## Colorado Springs Utilities NE Gravel Staging Area

### Lighting Plan

ATTACHMENT 5 – Lighting Plan

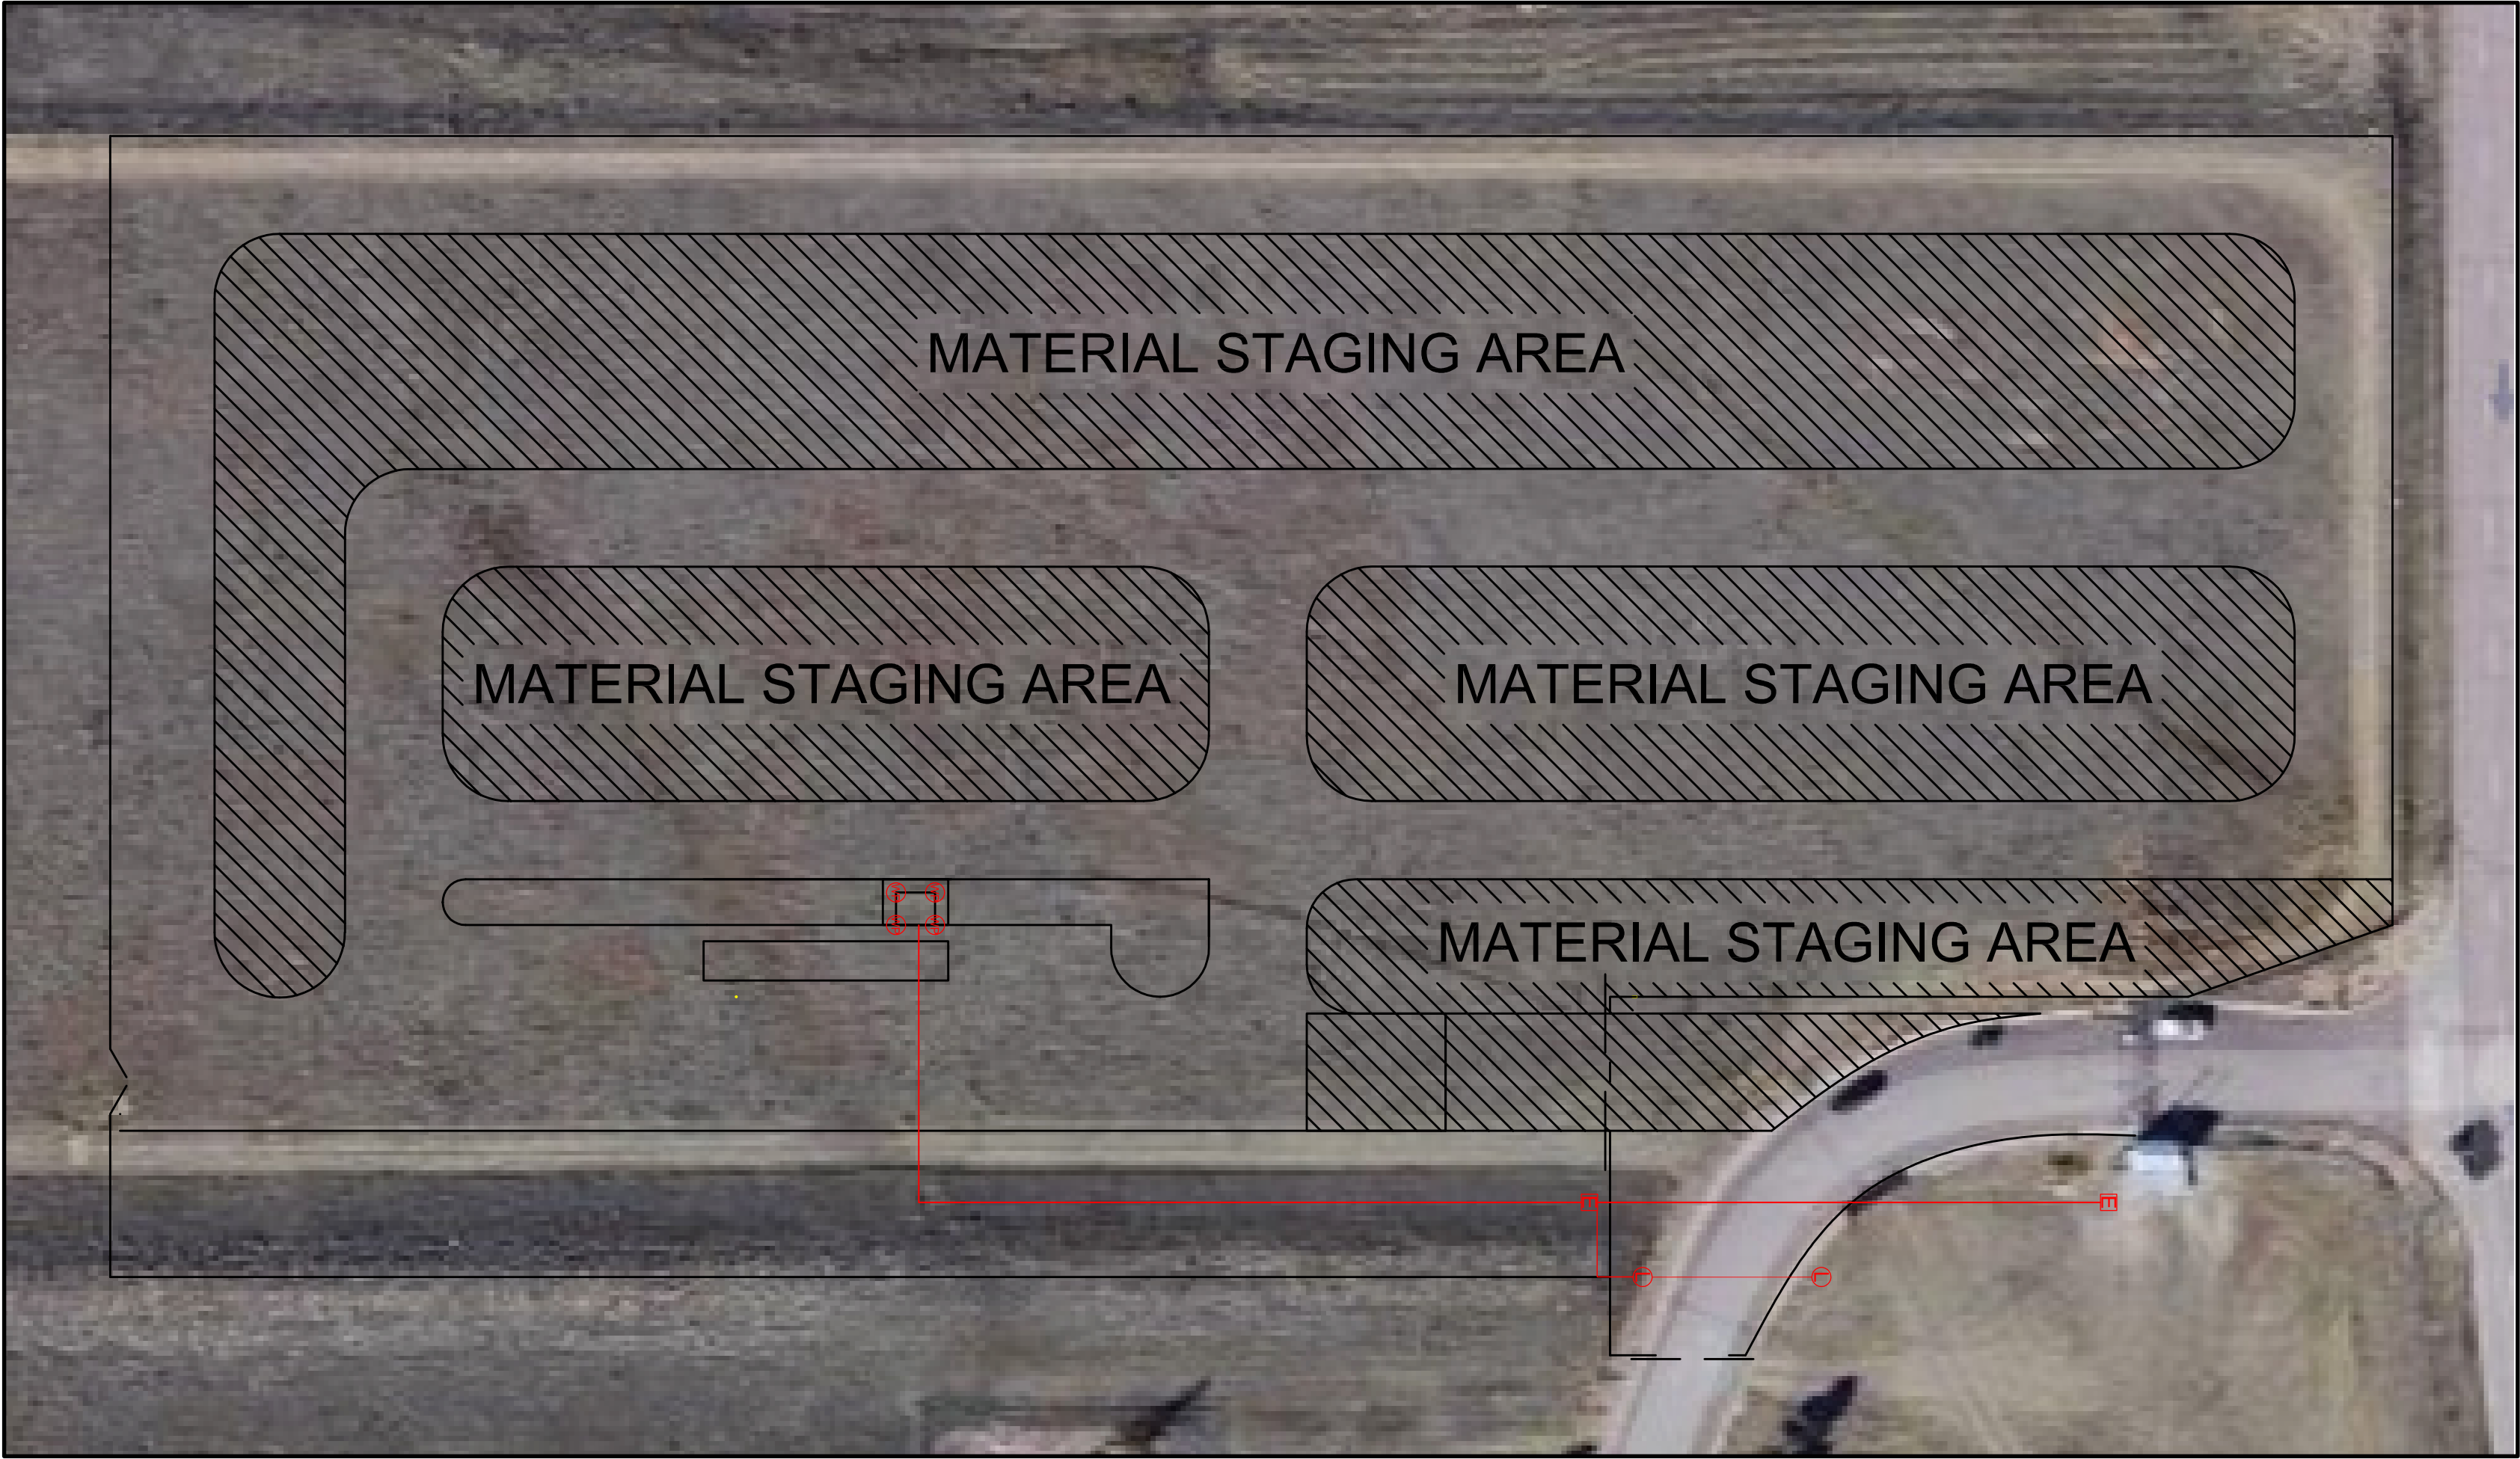
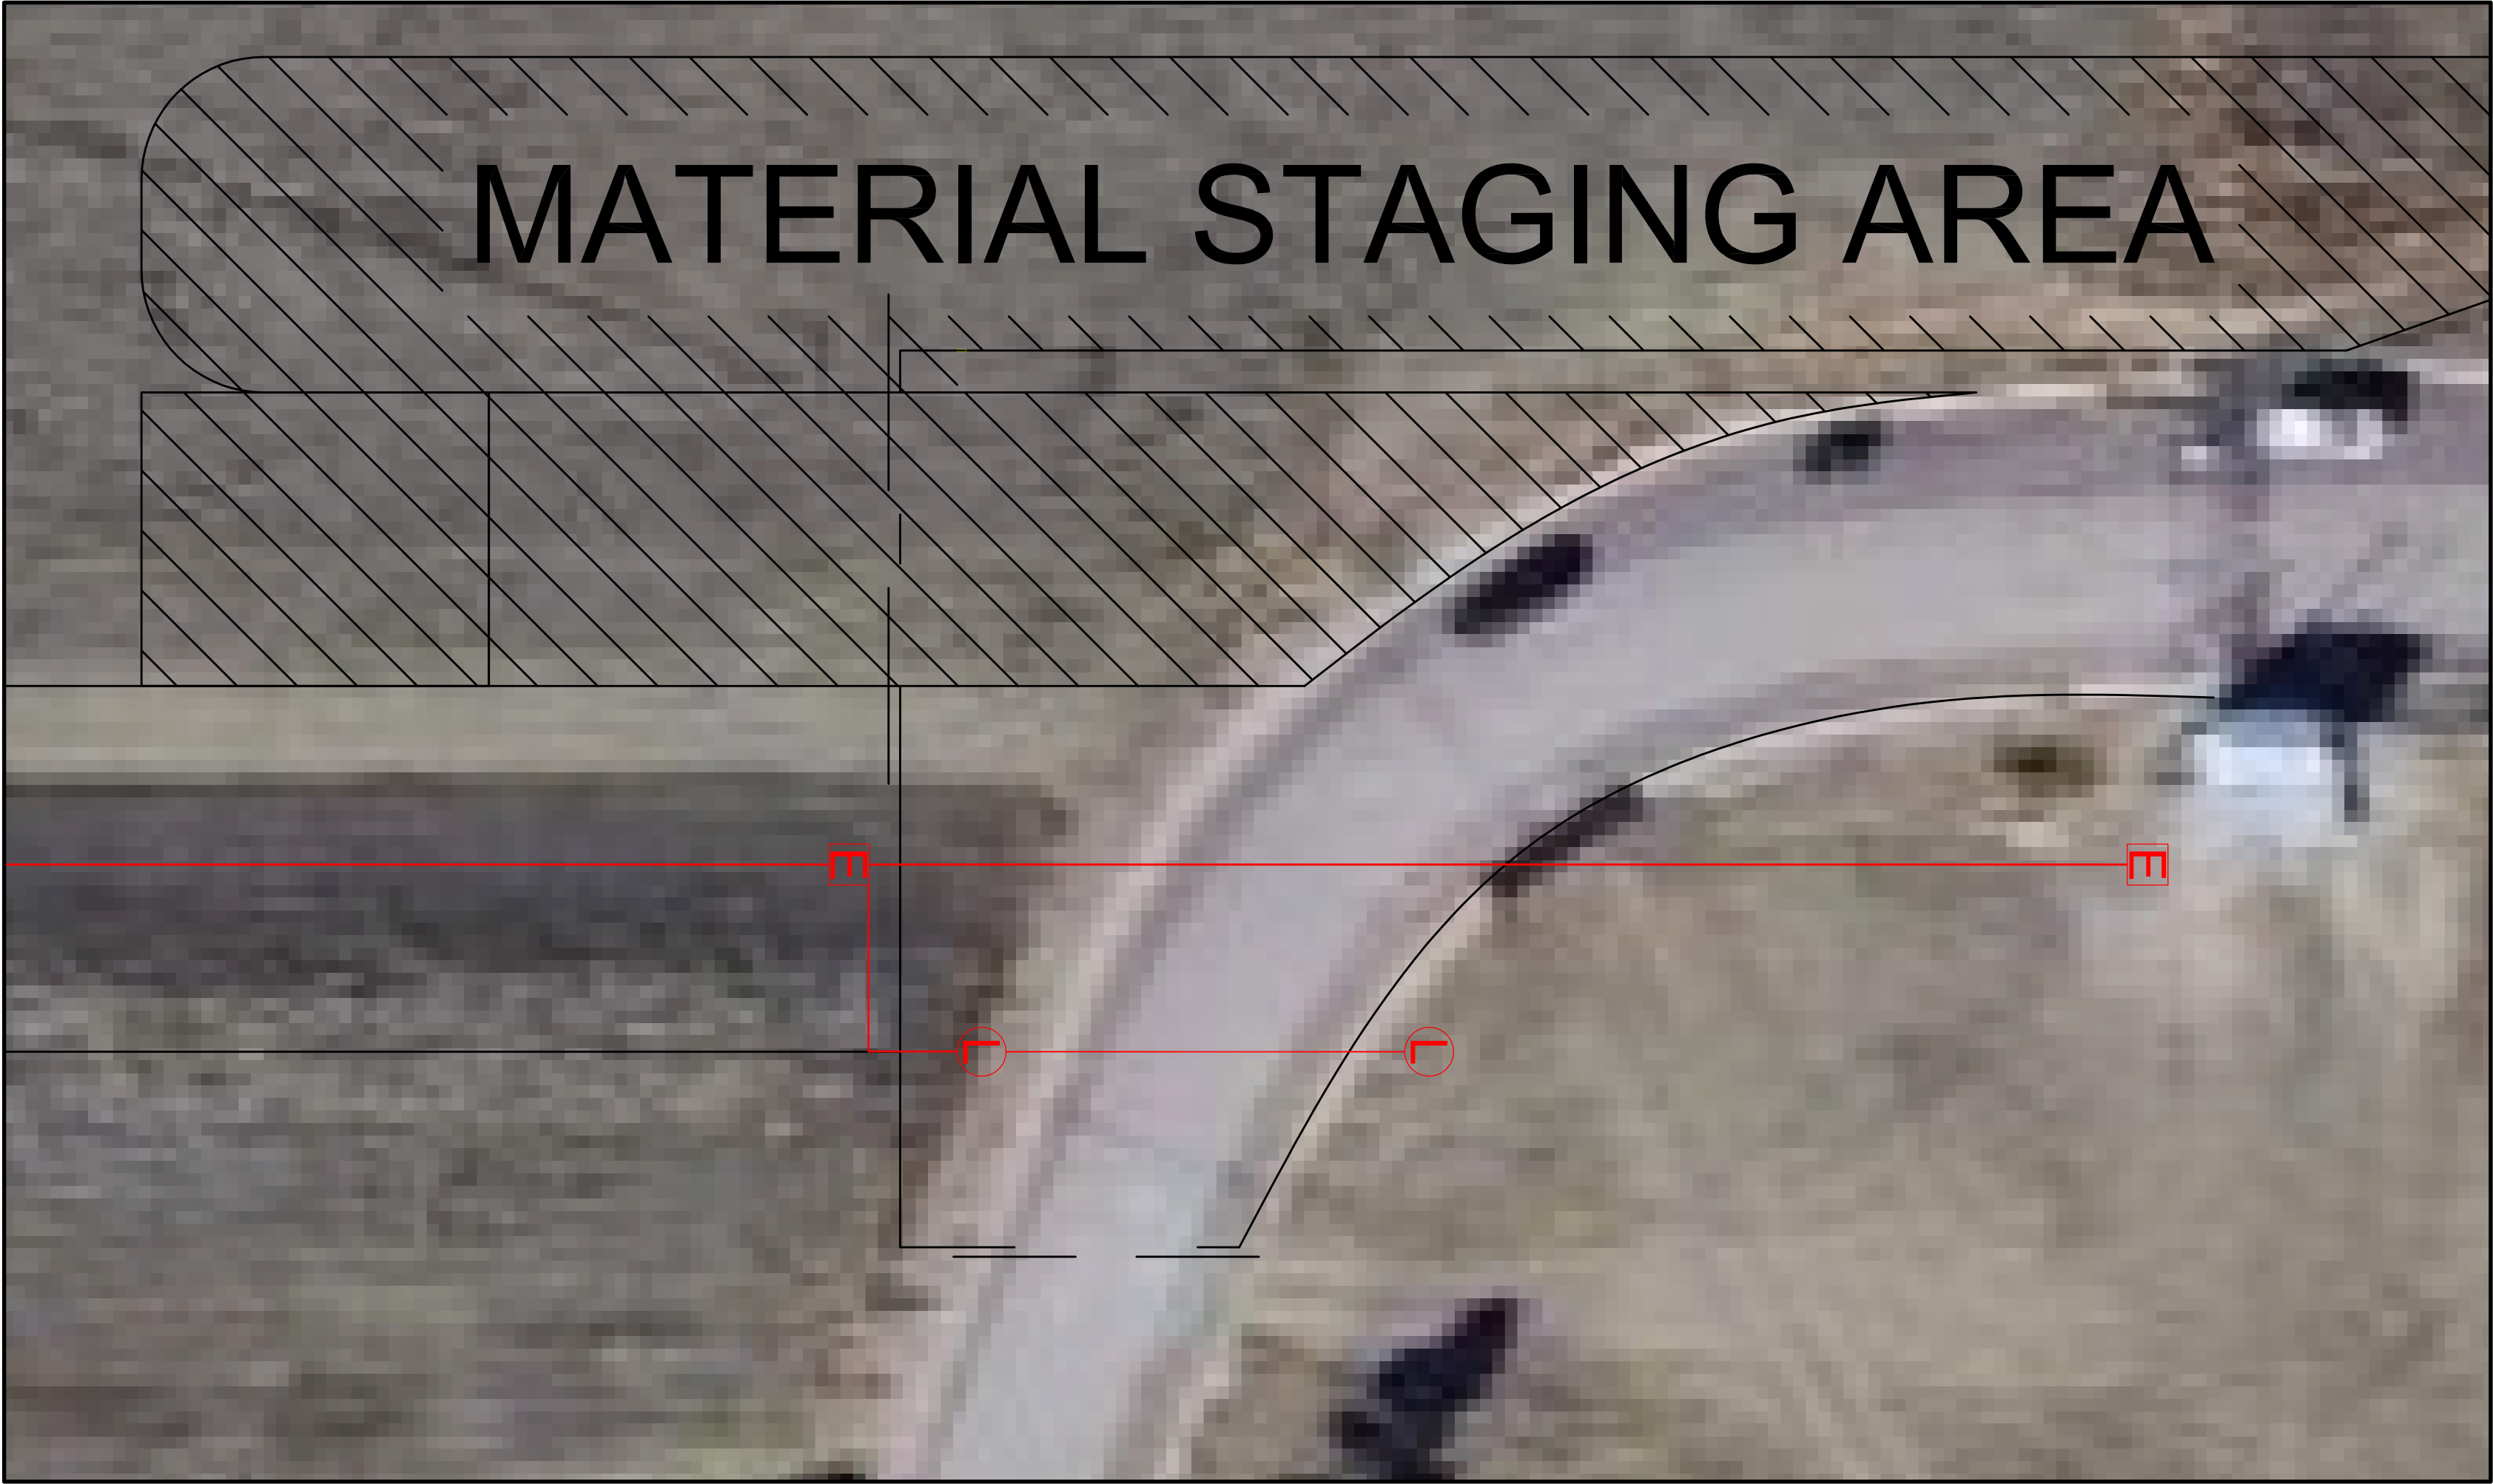
Include the following:

The location and height of all existing and proposed illuminating devices, including but not limited to, all parking area lights and external structural lights.

Detailed description of illuminating devices, fixtures, lamps, supports, reflectors, installation, and electrical details and other devices to include an elevation drawing. The description may include, but is not limited to, manufacturers specifications and catalog cuts sheets, and drawings. A key and legend may be required at the discretion of the PCD.

Photometric data and plan, including maps and diagrams furnished by manufacturers or similar showing the angle of the cut off or light emission.

Photometric plan depicting the lighting levels (foot candles) throughout the property, at property lines, and along any adjacent rights-of-way.

Please review lighting standards in LDC Sec. 6.2.3 and ensure compliance.

Max lighting levels shall not exceed 10 foot candles and lighting shall be measured at not more than 0.1 foot candles at property boundaries where adjacent to residential property or public right of way.

Max height of all lighting fixtures is 15 feet, except in parking lots, where 20 feet may be permissible.
